PLANNING AMENDMENT

FAYHILL AVE PINKYBEEK

H14-0198-98

PROPOSED GARAGE

SITE & FLOOR PLAN scale 1:100

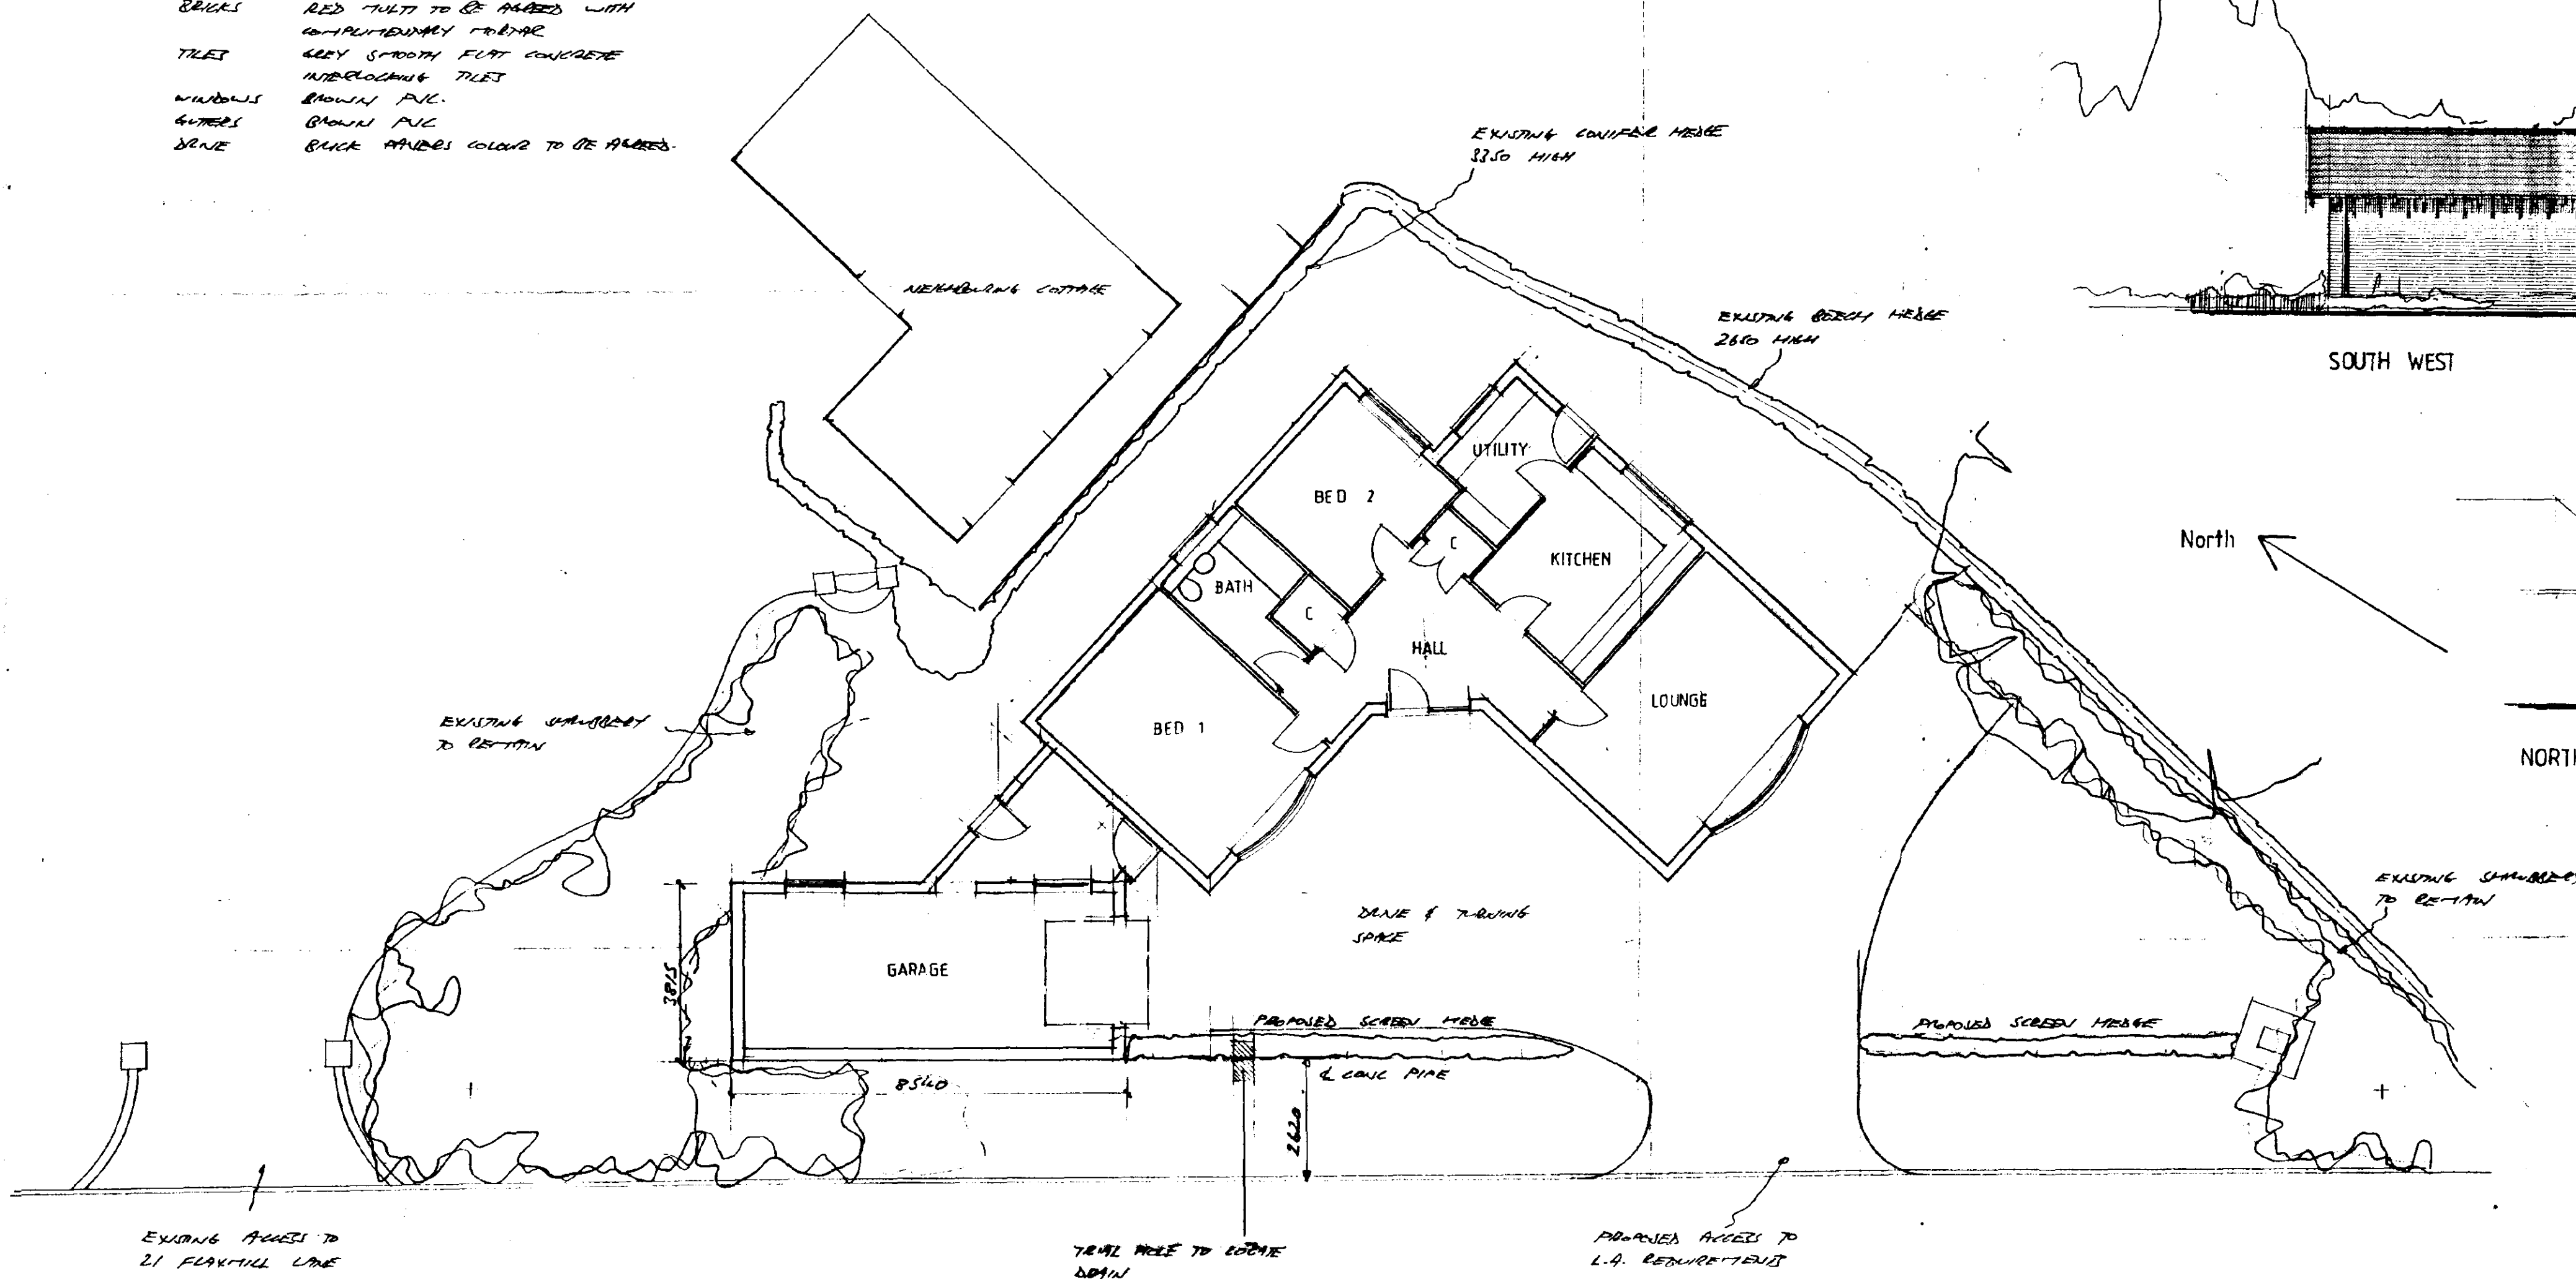
ADDITIONAL INFORMATION ON
PIPES DRAWN.
